## SPR EA1N and EA2 PROJECTS

### DEADLINE 5 - RESPONSES TO APPLICANTS COMMENTS AT D4 ON SASES WRITTEN REPRESENTATIONS SUBMITTED AT D1

Interested Party: SASES    PINS Refs: 20024106 & 20024110

Date: 3 February 2021

## **Figure 29.37**

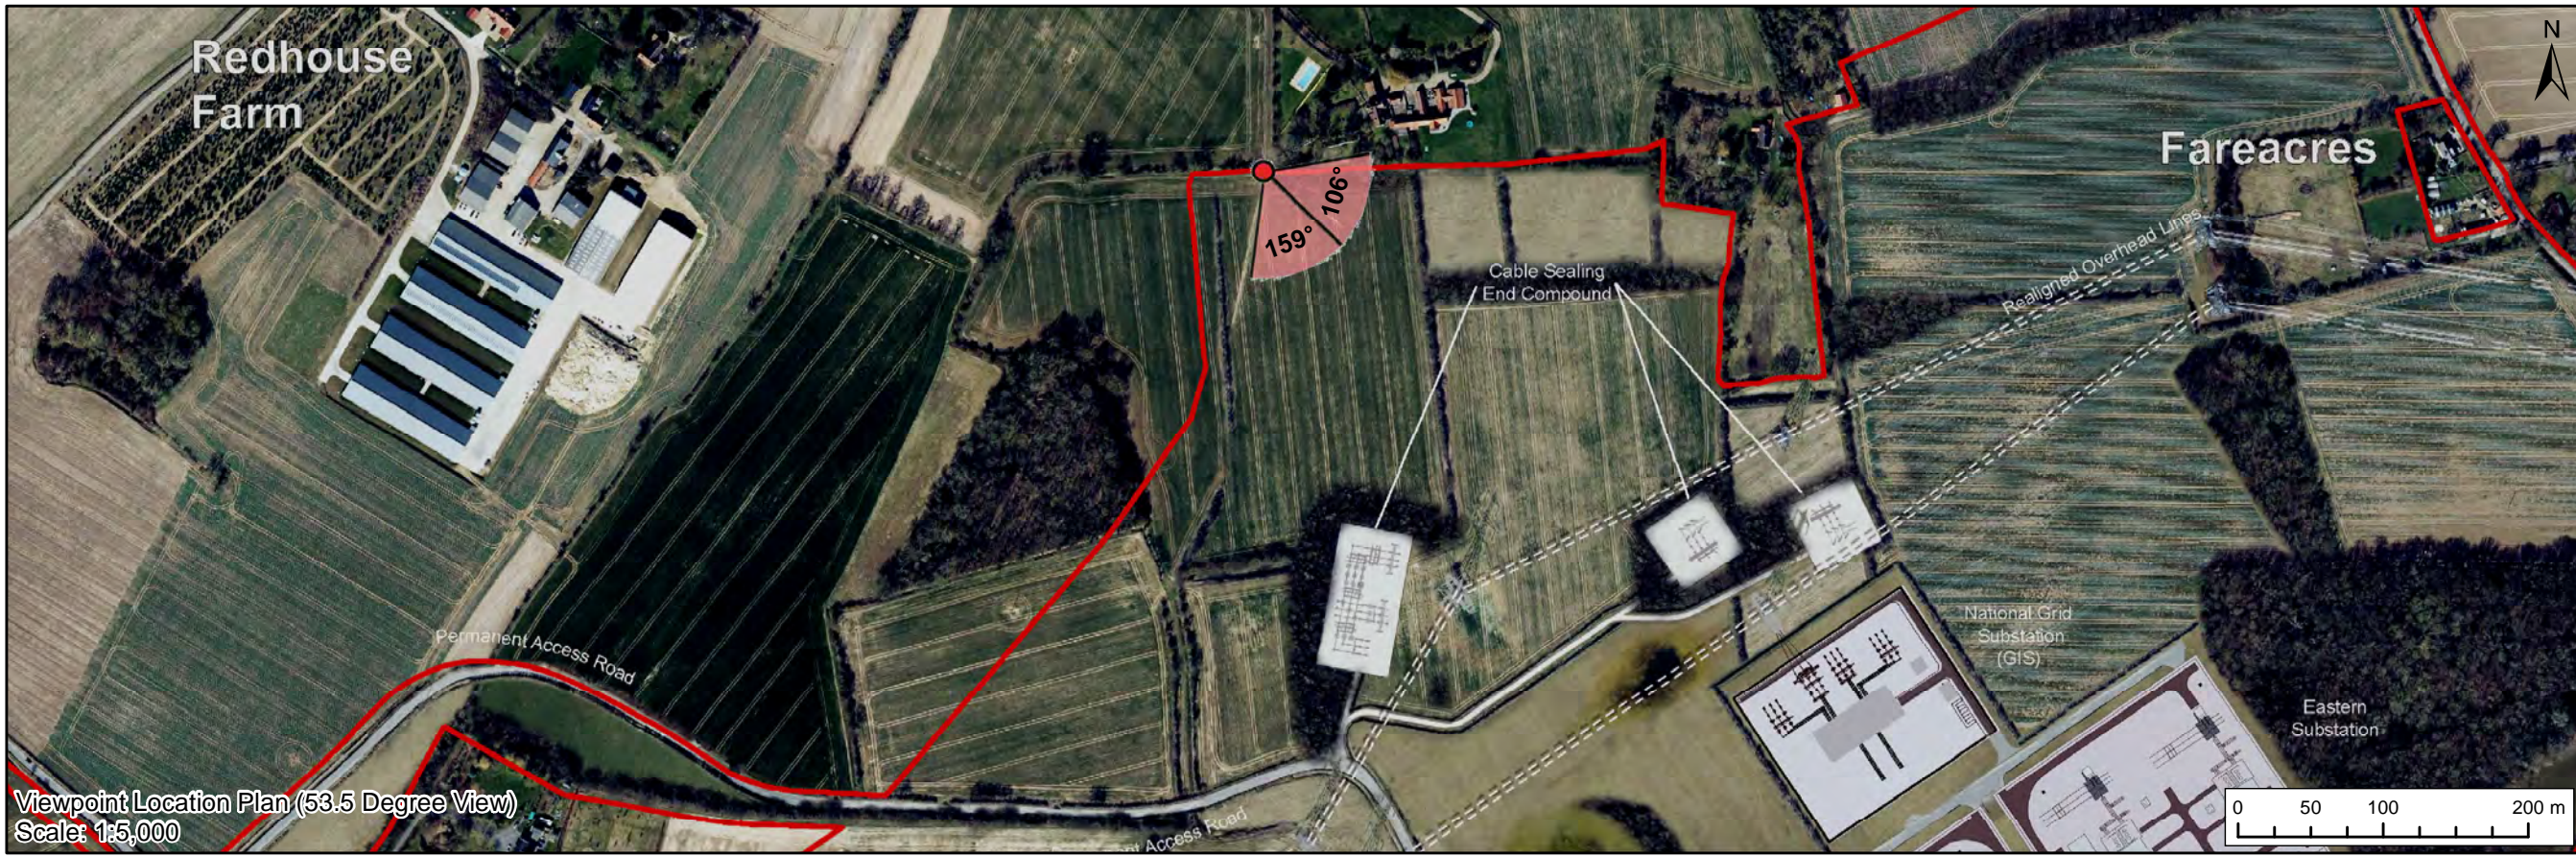
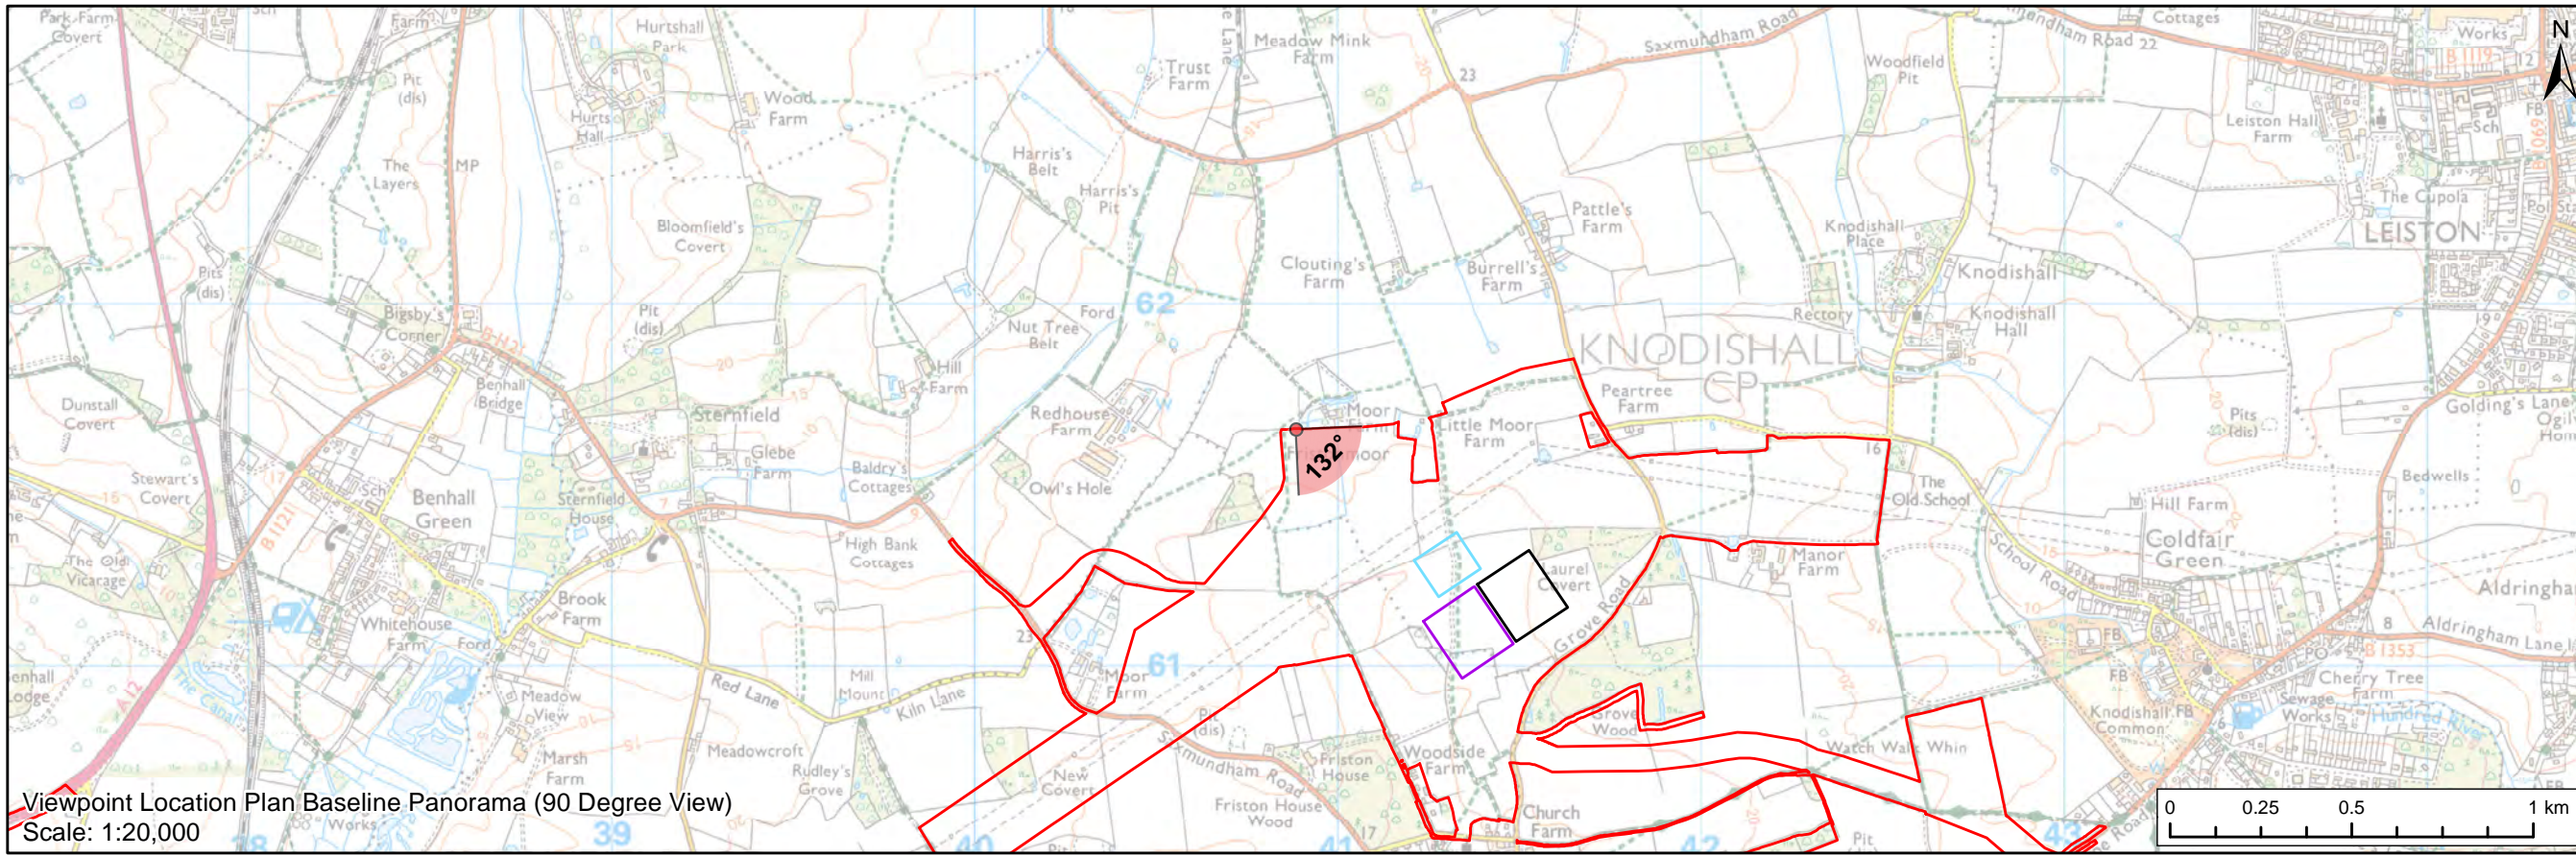
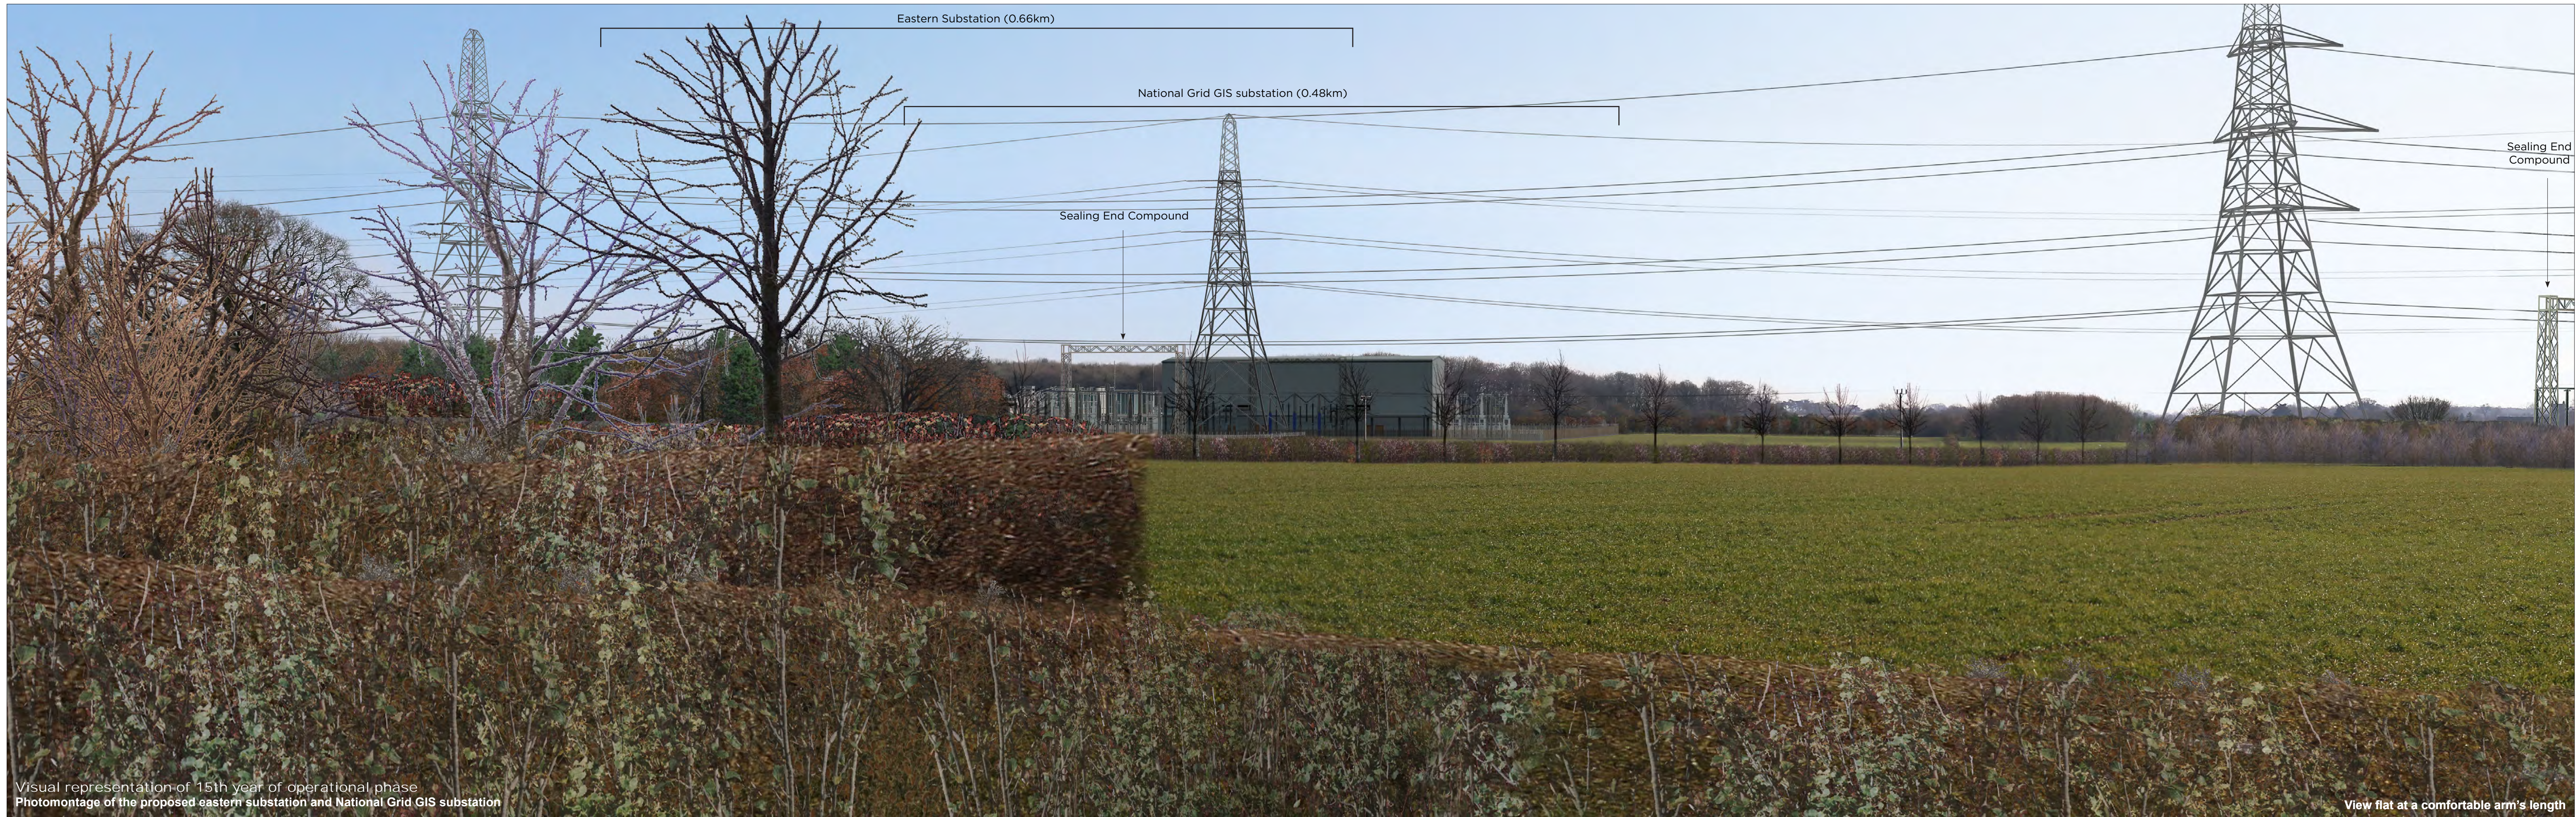
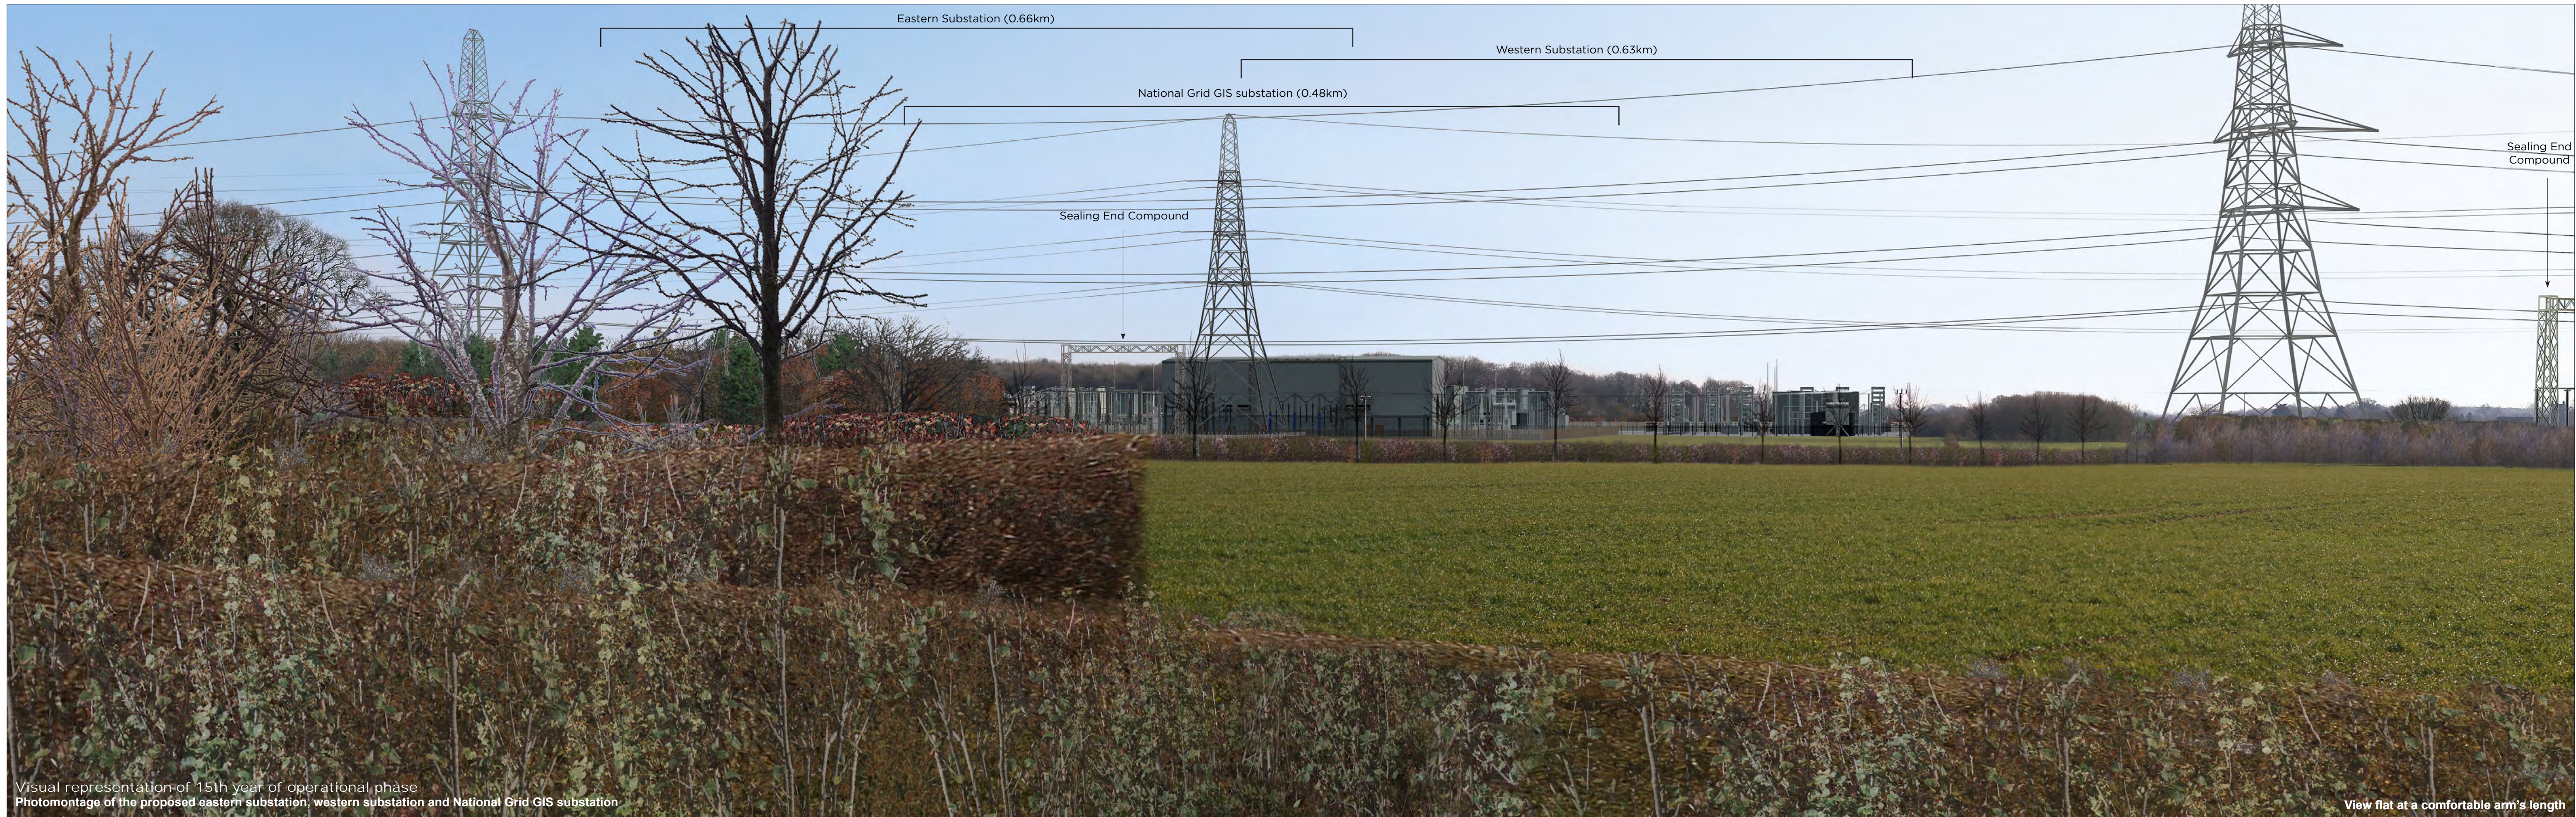
9. The revised photomontages from Vp 5 which is presented on two frames now illustrates more clearly the impact of the development on the distinctive character of the landscape to the north of the village in which the presence of the church makes a significant contribution. The revised photomontages from Vp 5 illustrates how the landscape to the north of the substations will be severed from the village and there will be a total loss of the current relationship between this landscape and the village. The *Landscape and Visual Impact Assessment Addendum* accepts that the changes made during the examination process will not reduce the visual impact from this viewpoint or other viewpoints to the north. From Vp 5 the effect will remain significant, adverse and permanent.
